REQUEST

Current Zoning: O-2 (office)
Proposed Zoning: MUDD(CD) (mixed use development, conditional)

Approximately 1.55 acres located along the southeast side of Colonial Avenue, along the west side of Vail Avenue, and the northeast side of Randolph Road.

Flagship Healthcare Properties, LLC

4 EAST ELEVATION - ADJACENT PARCEL

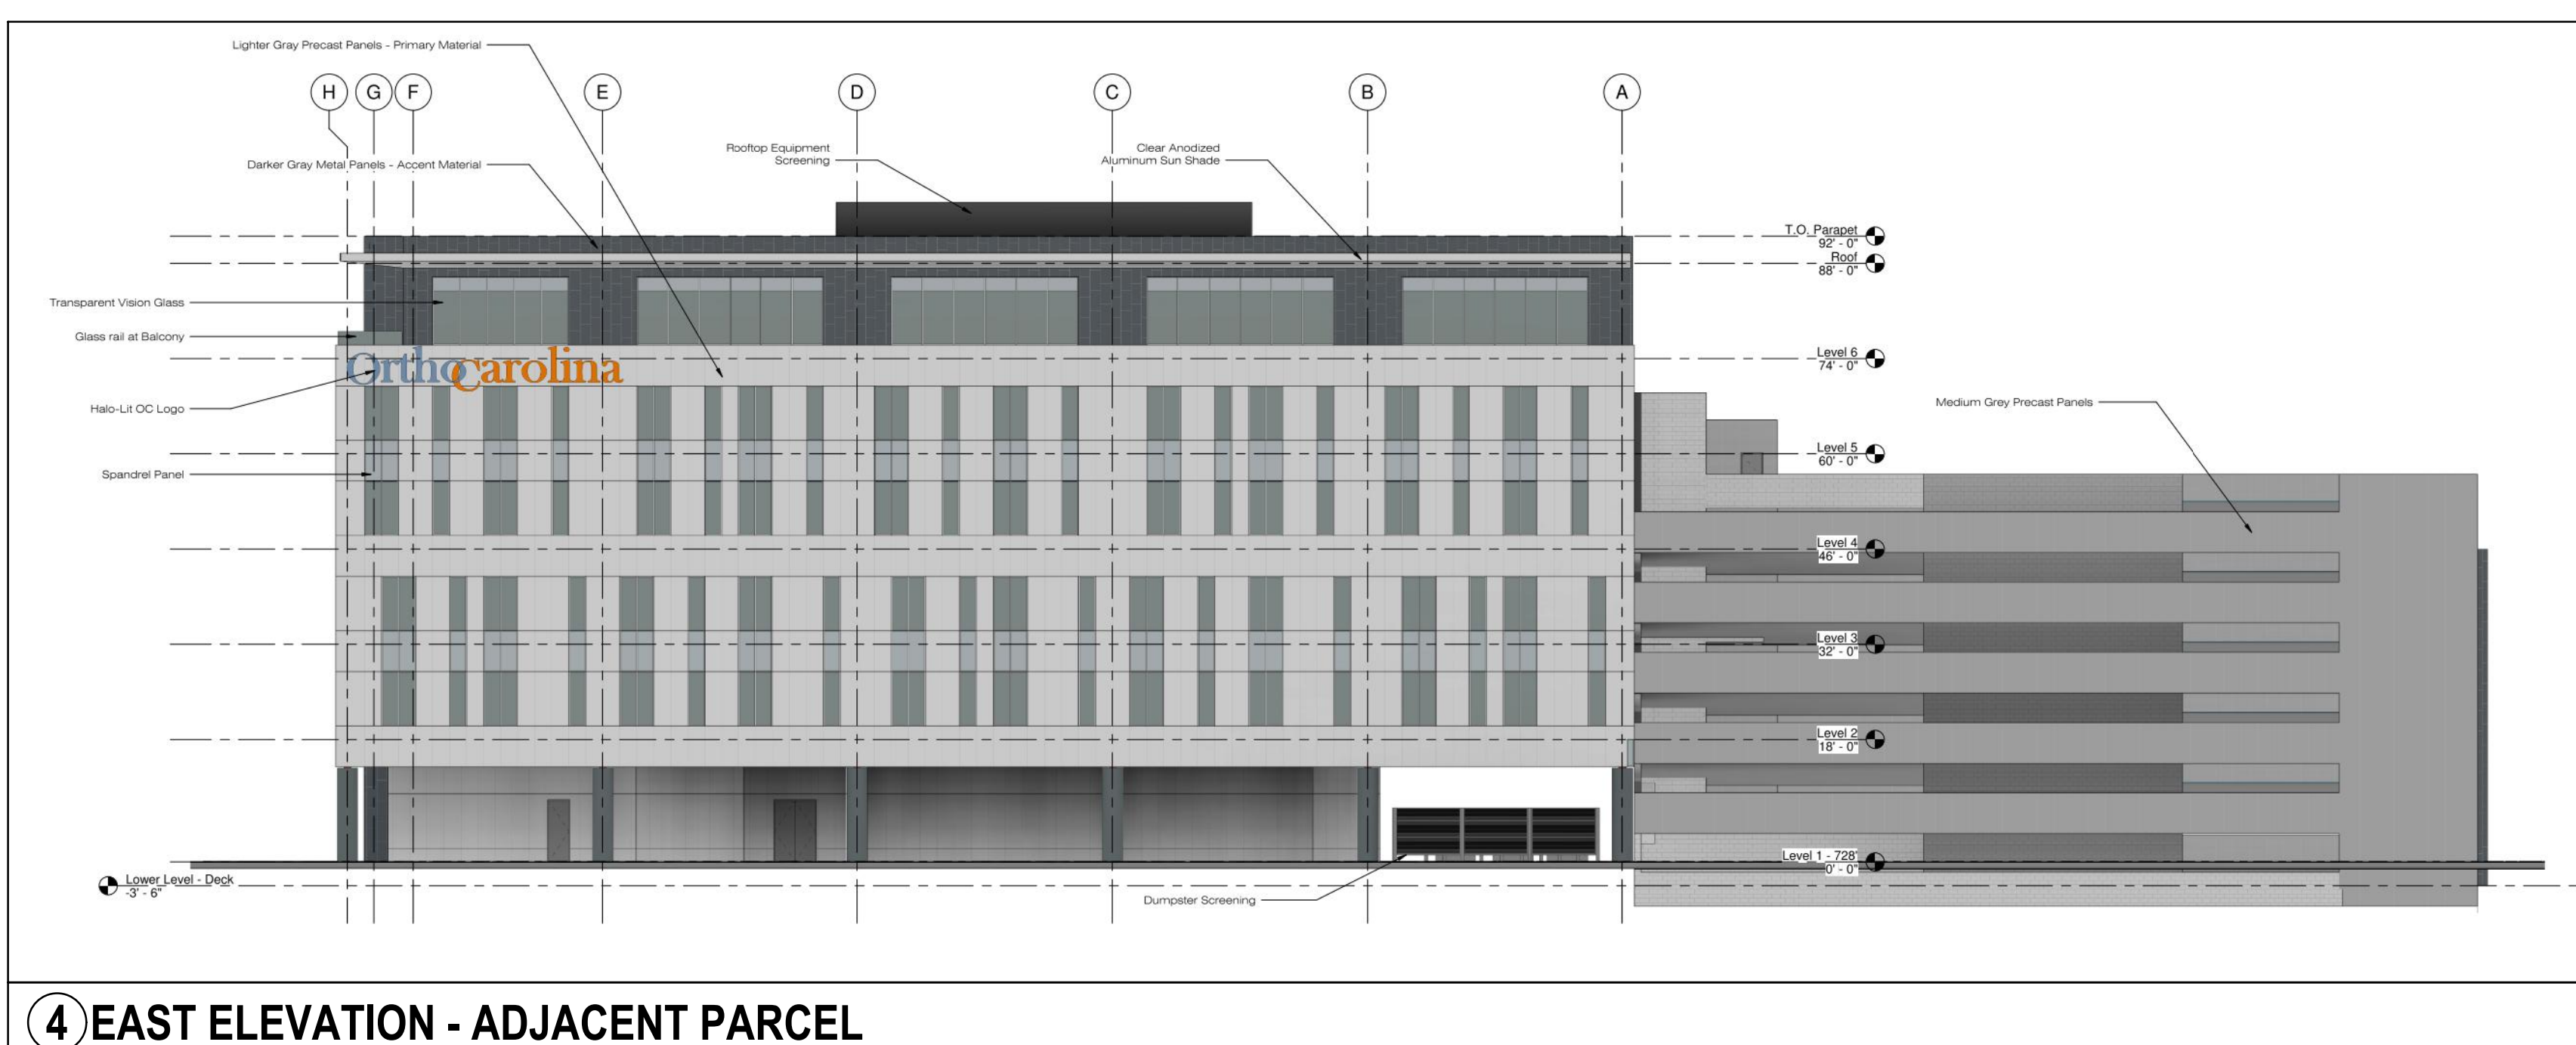
1. Under Site Development Data remove reference to number of stories.
 2. Label 8-foot sidewalk and 8-foot planting strip along Randolph Road and Vail Avenue.
 3. The setbacks labeled on the site plan are different from the 14' noted under Rezoning Summary. The setbacks will need to match what is shown on the site plan.
 4. On the Elevations sheet label east, west elevation (or identified street view). Signage is not part of this review.
-
